Fwd: Tank at Whole Foods

I got these comments from DPW after I signed off on this administrative authorization for 2 Somerset Street. I believe this is part of the building permit review, so I thought you could share Keith's comments with the plan reviewer. I am adding Keith in case there are questions.

GRIND2ENERGY TANK
CONCRETE PAD

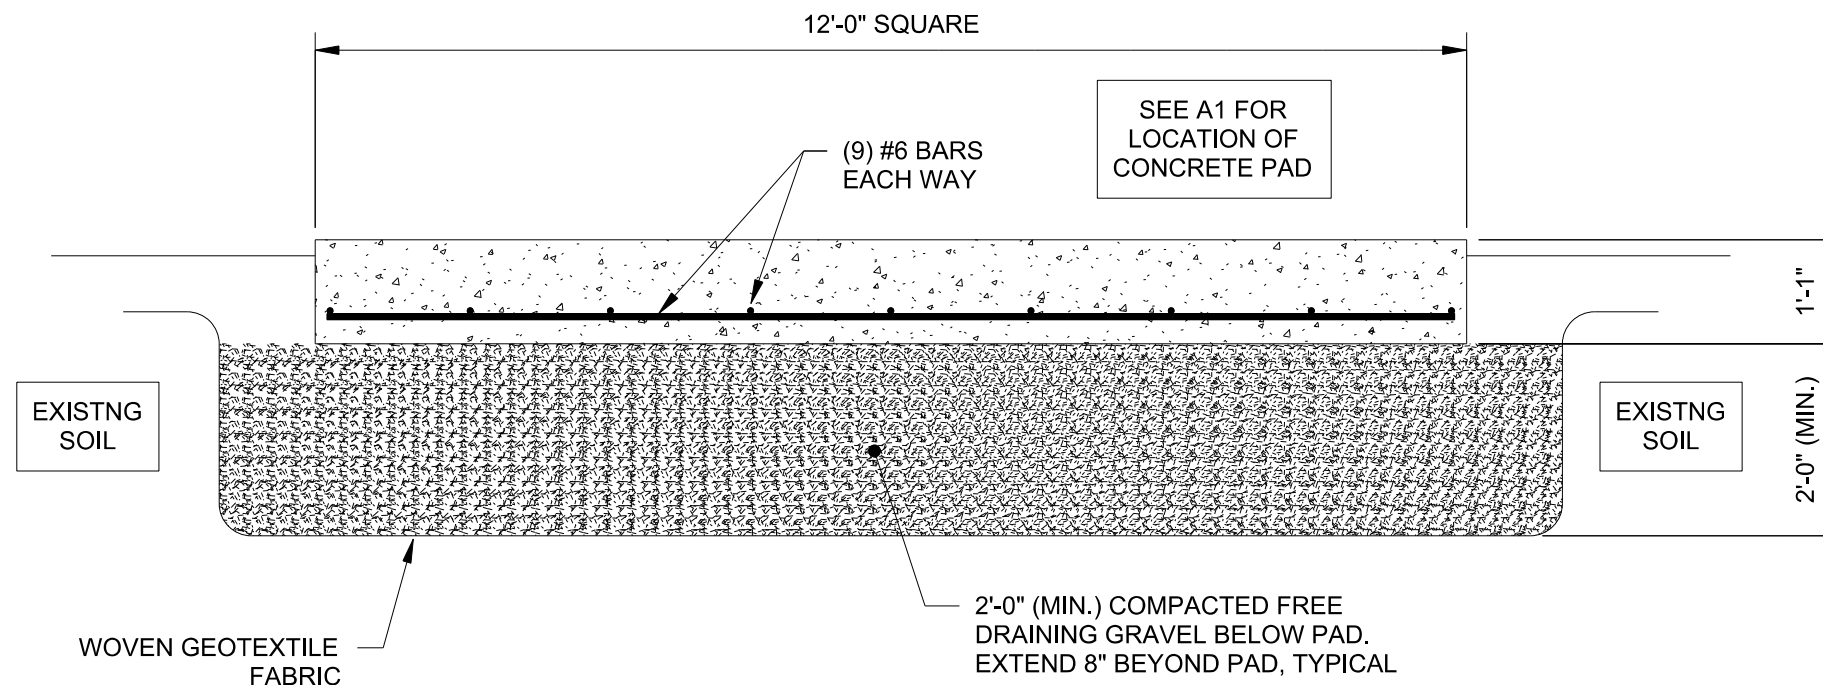
- The concrete pad detail indicates that two feet of compacted gravel and the tank pad is to be placed on soils with adequate soil bearing capacity.
 - The applicant should specify how adequate soil bearing capacity shall be determined onsite by the contractor. Has any geotechnical investigation been completed? Any known issues with the existing pad?
